Direct Dial: 07823608338
Our ref: L01593341
11 August 2025

Arrangements for Handling Heritage Applications Direction 2021

MONKS HOUSE, BOURNE ROAD, SPALDING, LINCOLNSHIRE Application No. H16-0526-25

PROJECT TITLE: MONK'S HOUSE				SCORER HAWKINS ARCHITECTS Lodge Farm Barns Skendleby, Spilsby Lincolnshire, PE23 4QF 01754 890089 projects@scorerhawkins.co.uk www.scorerhawkins.co.uk
DRAWING TITLE: PROPOSED SECTION B-B				
DRAWING NO: 2548-PP05	REVISION: A	PAGE SIZE: A3	SCALE: 1:50

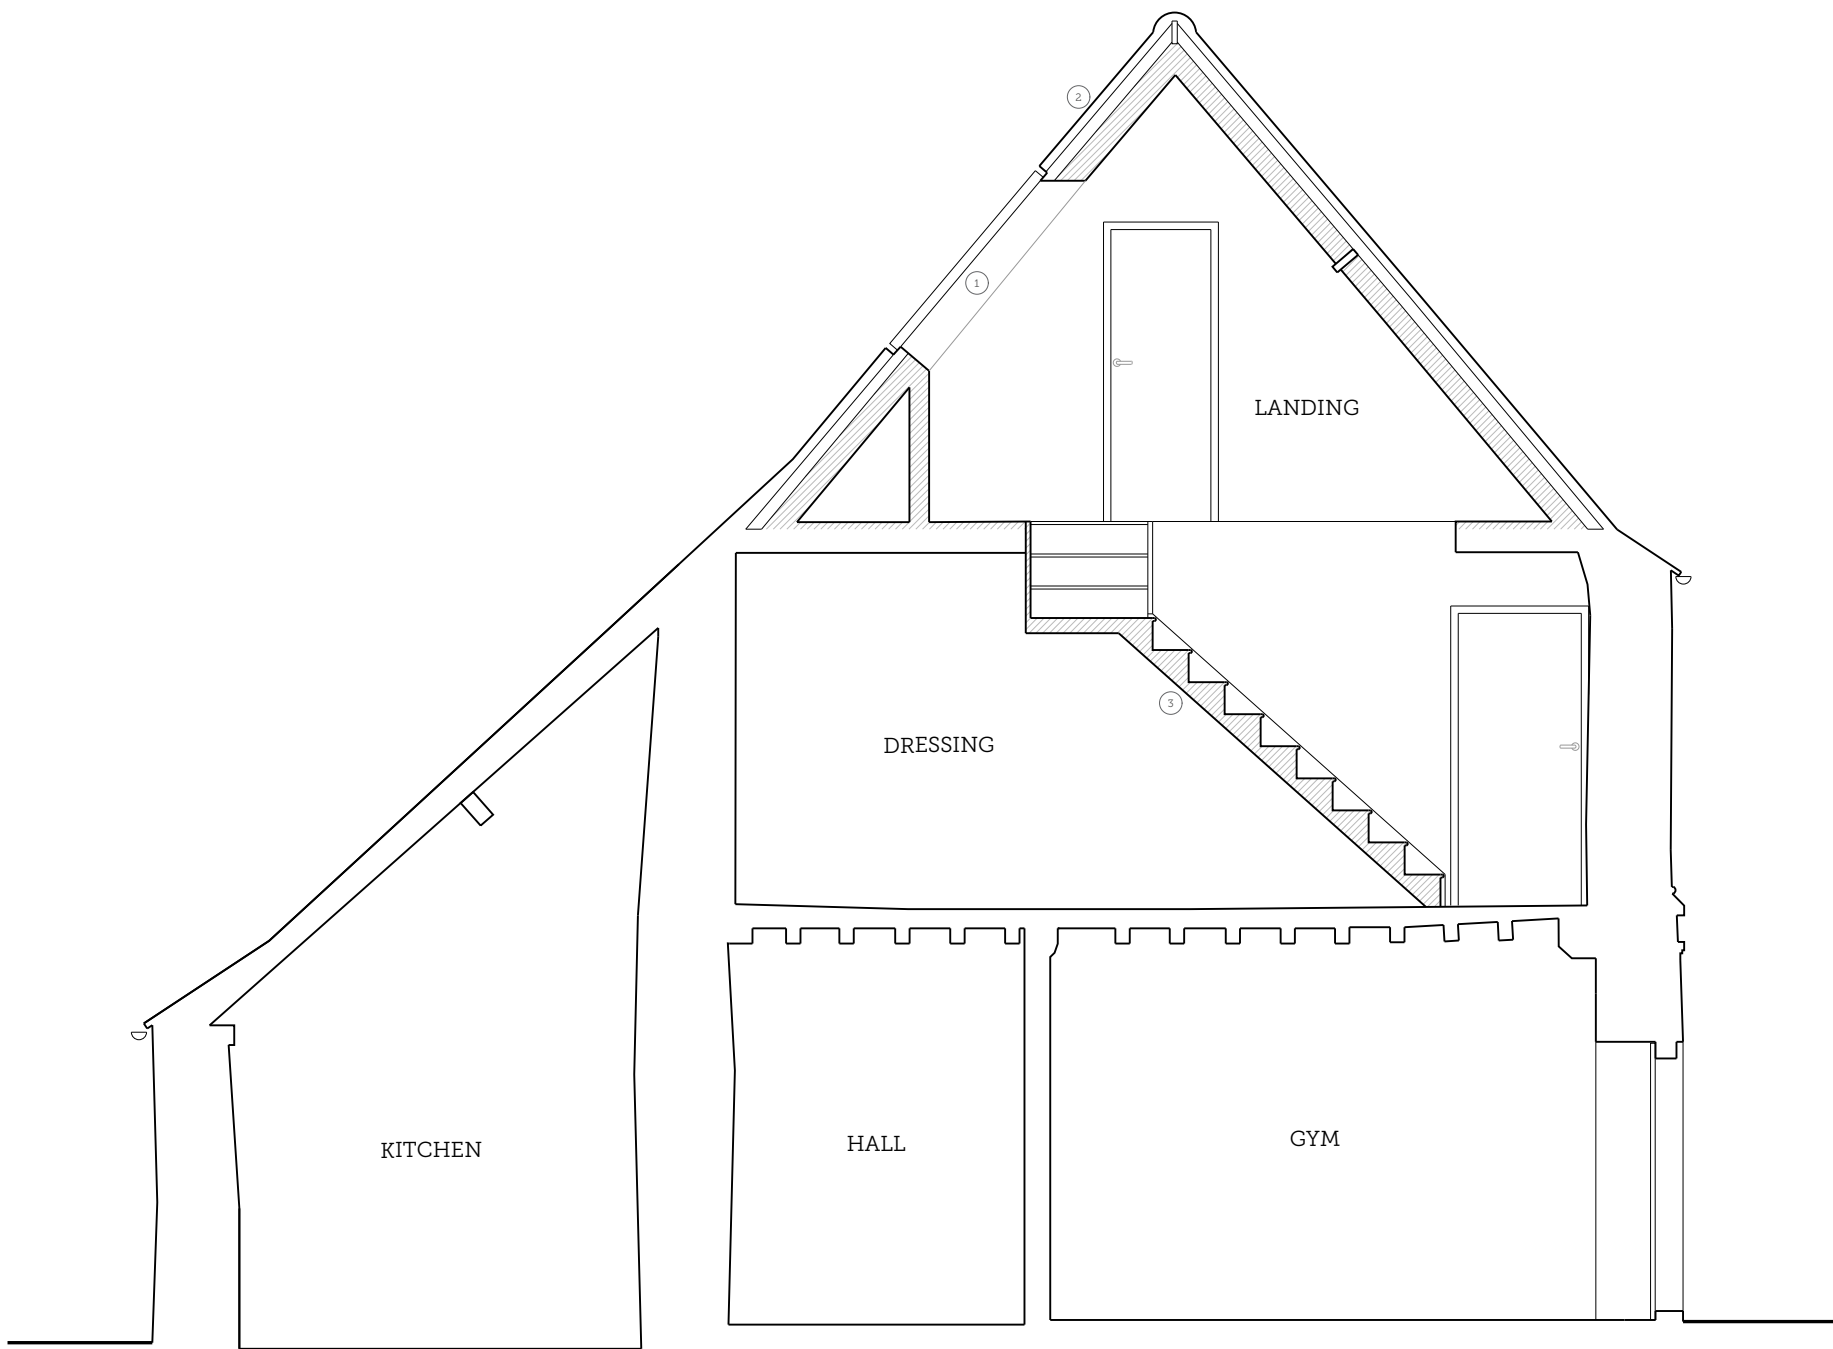
Some section elevations of the proposed staircases have been provided, however the

information is limited and of low digital quality, so much so that some annotations are illegible.

PLANNING			
PROJECT TITLE		MONK'S HOUSE	
DRAWING TITLE		FIRST FLOOR PLANS	
DRAWING NO.	REVISION	PAGE NO.	SCALE
2548-PP02	B	A3	1:100

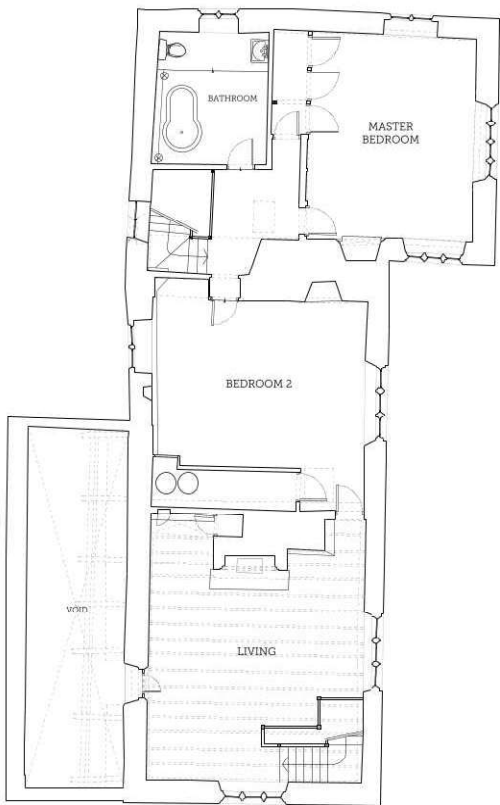
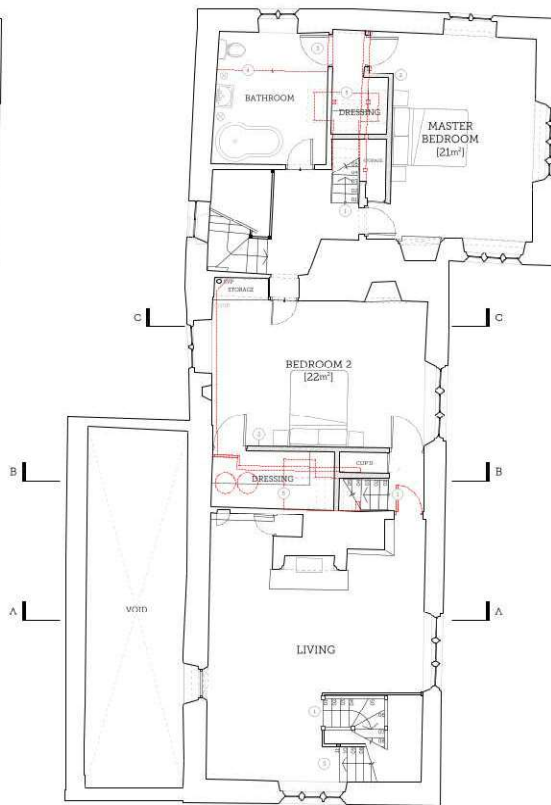
We previously advised that details of the proposed three new staircases should be provided to enable an adequate impact assessment. The Heritage Statement has not been updated, and the Impact Assessment section still does not adequately describe, or assess the impact of, proposed works. No further understanding is provided of works required to facilitate the new staircases and their impact on fabric at first and second floor.
